13 July 2018

Our Ref: AL/67/18/PL

Re: AL/67/18/PL Land West of Fontwell Avenue (middle plot)

APPROVED SITE PLAN 1:500

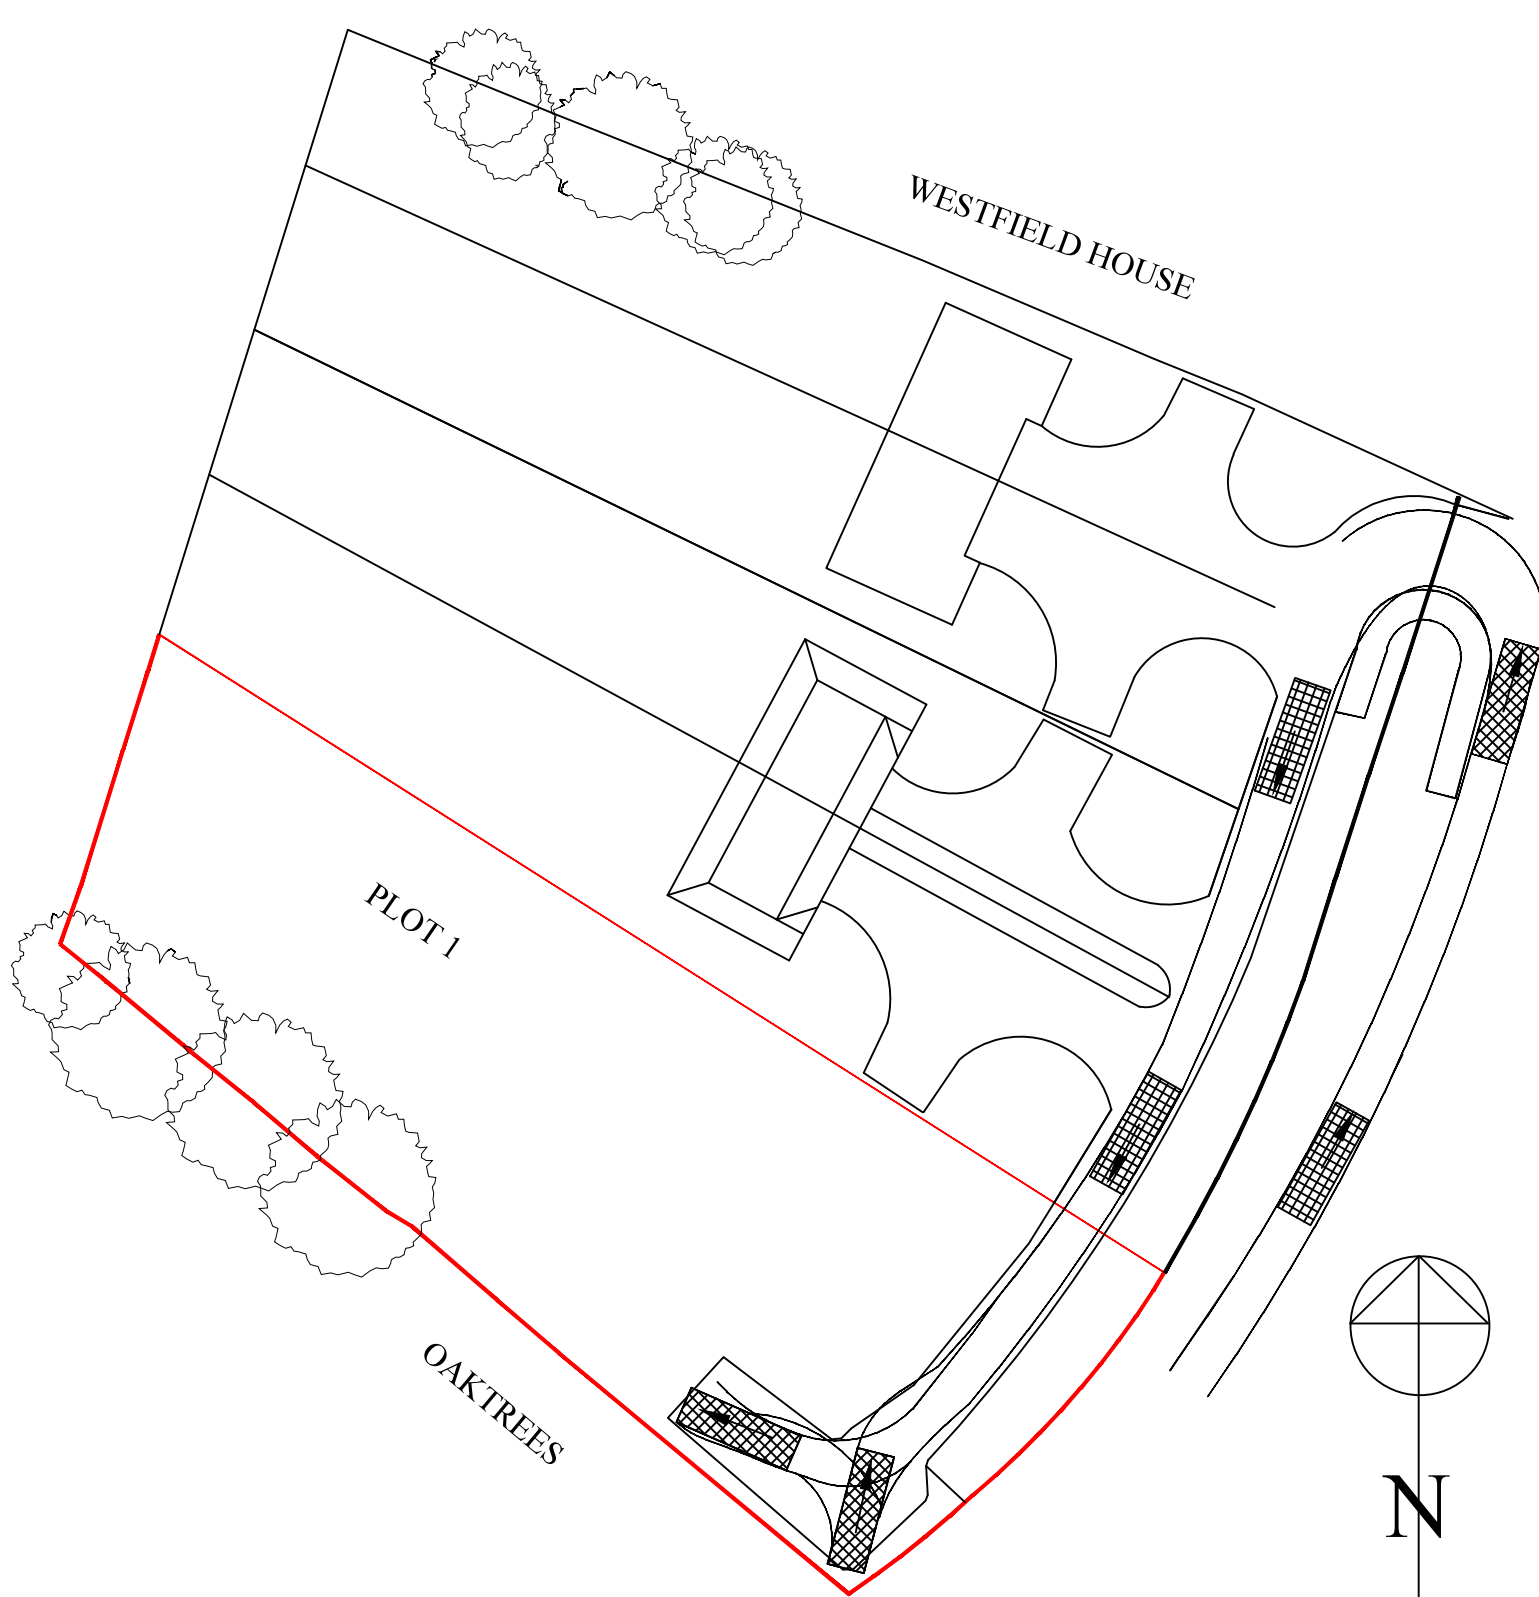
You have effectively applied to remove condition 06 of AL/122/17/PL but we cannot do this as this would mean then that you would not need to have the access shown on the approved drawing (the access at the northern end) implemented before you occupy the dwelling. This would result in an unsatisfactory situation. Therefore, this application would be refused.

I had assumed that your issue was that your approved plans show the large vehicle turning area at the southern end of the new internal drive and you would not be able to comply with condition 08 (parking & turning) of AL/122/17/PL because if AL/136/17/PL is approved with the new access, then this would not be provided. However, this would not matter as that large vehicle turning area is not within your red edge and as such condition 08 only requires you to provide the parking & turning facilities within the applicant's part of the site.
